Response to Planning application from Hertfordshire County Council (T and CP GDP Order 2015)

District ref: 6/2020/0913/COND
HCC ref: WH/1830/2020
HCC received: 11 May 2020
Area manager: Alan Story
Case officer: Ania Jakacka

STANBOROUGH SCHOOL LEMS FORD LANE WELWYN GARDEN CITY AL8 6YR

Submission of details pursuant to conditions 1 (external materials) and 2 (construction method statement) on planning permission 6/2017/2972/FULL, dated 22/02/2018

SITE SET UP PLAN
CPH/SP 1 of 2 - 17/04/20

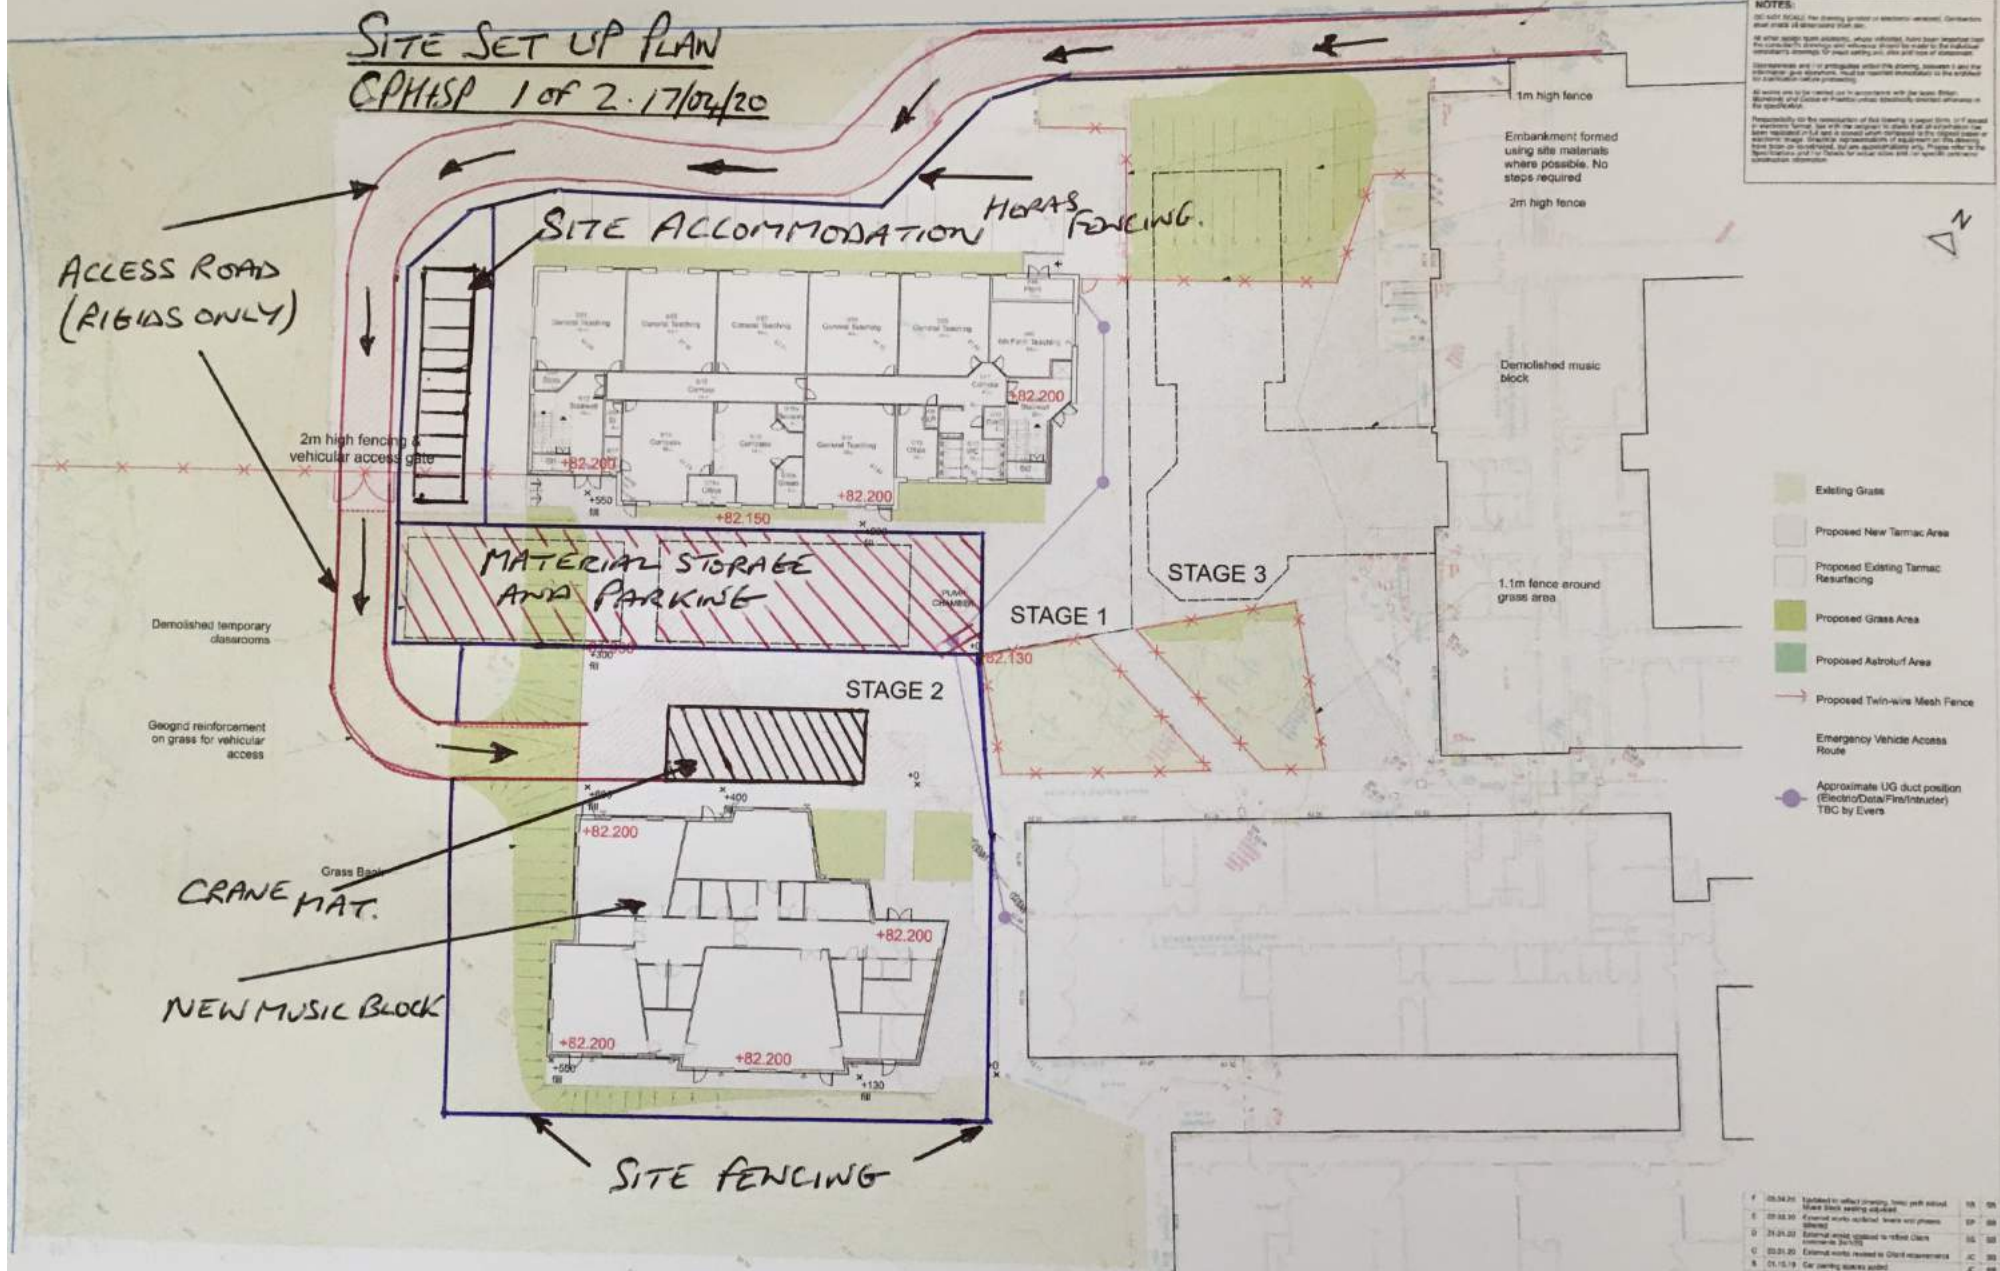
The submitted documents now for consideration are: T J Evers Rev CPHSP 1 of 2 12.07.18 2155040101 Rev F plan and Construction Environmental Management Plan Stanborough School Music Block 17_04_20).

- (a) the parking of vehicles, of site operatives and visitors during each stage of the building project-satisfactory.
- (b) loading and unloading of plant and materials during each stage of the building project-satisfactory
- (c) storage of plant and materials used in constructing the development- satisfactory

- (d) the erection and maintenance of security hoarding including decorative displays and facilities for public viewing, where appropriate- satisfactory
- (e) siting and details of wheel washing facilities-satisfactory
- (f) measures to control the emission of dust and dirt during construction- satisfactory
- (g) a scheme for recycling/disposing of waste resulting from demolition and construction works-satisfactory
- h) construction vehicle numbers and type- satisfactory
- i) Construction access arrangements- satisfactory
- j) Cleaning of site entrances, site tracks and the adjacent public highway- satisfactory
- k) Timing of construction activities to avoid school pick up/drop off times- satisfactory

The Highway Authority raises no objection to the discharge of condition 2. The Highway Authority has already recommended that this condition is discharged under 6/2020/0455/COND.
